## CHERWELL DISTRICT COUNCIL

### MEMORANDUM

#### **Ref: 18/00347/DISC – Discharge of condition 19 (LEMP) of 16/00263/F, Building 488 Heyford Park Camp Road – Ecology Comments**

I have reviewed submitted Landscape and Ecological Management Plan (LEMP) Heyford Park Bicester Parcel 6 by Liz Lake Associates dated January 2017 and have the following comments to make.

1619 A2 01 Rev J Detailed Planting Proposals

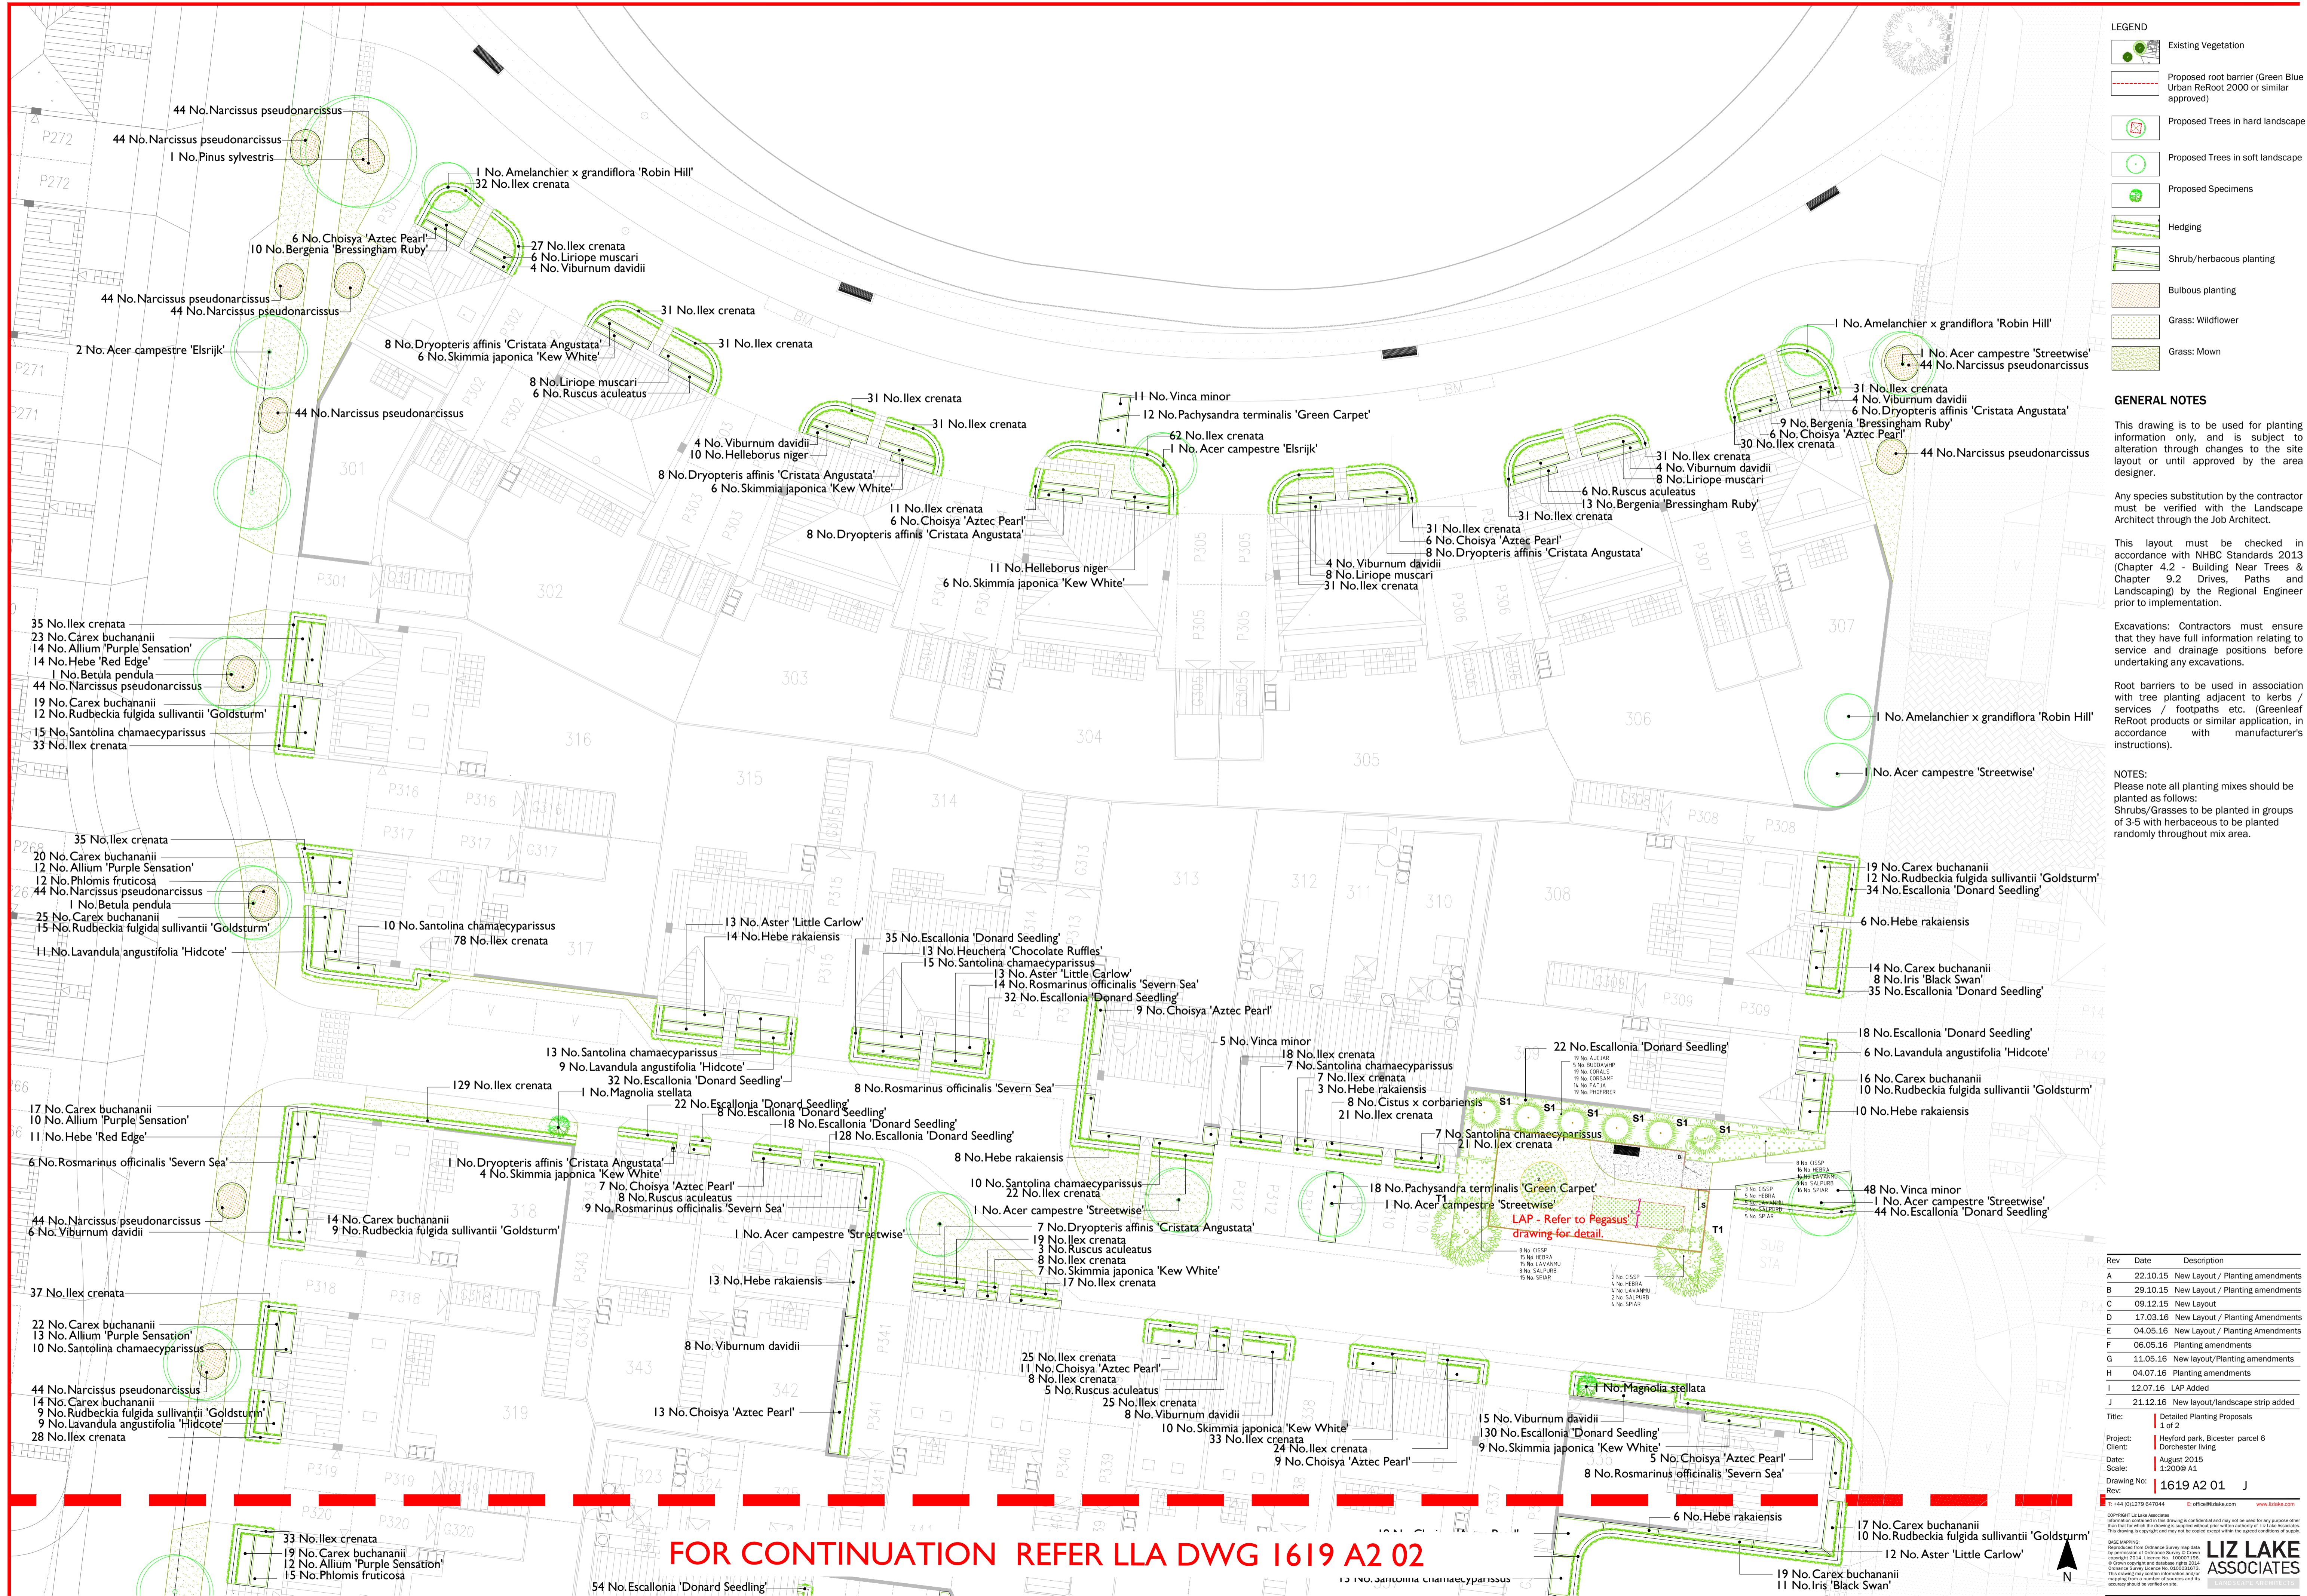
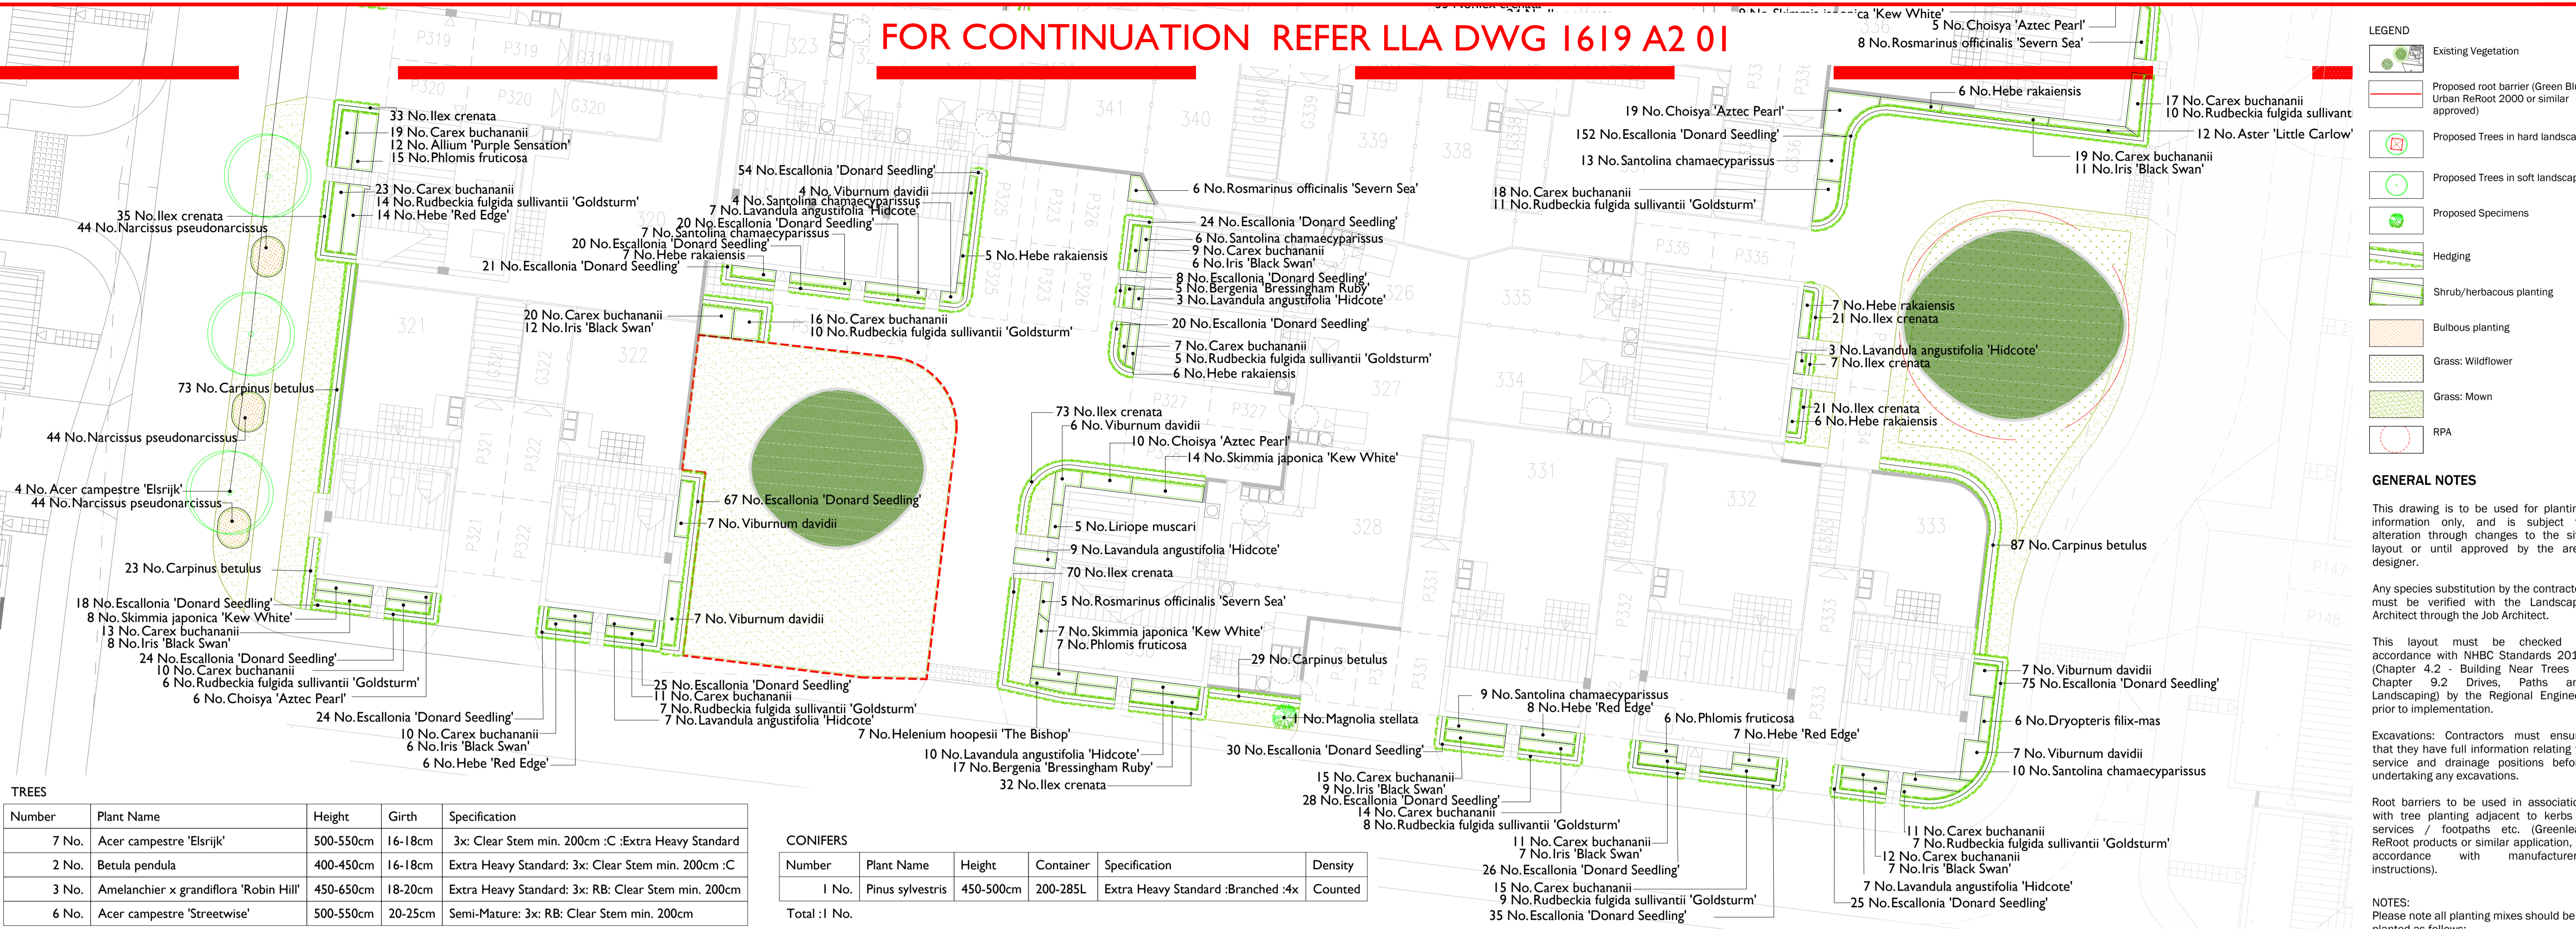
Paragraph 5.3.2 regarding the species mix of the native hedgerows makes reference to the planting schedules in Appendix 1, the species listed here for the hedgerows either not native or are not local provenance to this area. It is not clear whether this is just because there are no native hedgerows identified to be planted or retained in this parcel if there are none in this parcel then this should be clear as it is currently misleading. Paragraphs 5.3.3 – 5.3.16 go on to detail management of the native hedgerows, but again it is misleading if there are no native hedgerows in this parcel to be managed. However the management approaches detailed do seem appropriate.

Sections 6.1, 6.2 & 6.3 all detail very good objectives and prescriptions in relation to bird, bats and lighting but there is a lot of reference in the text to “to be agreed with the consulting ecologist” for example in relation to the location of bird and bat boxes and log piles. These should really be already agreed and detailed on the attached plan in appendix 1.
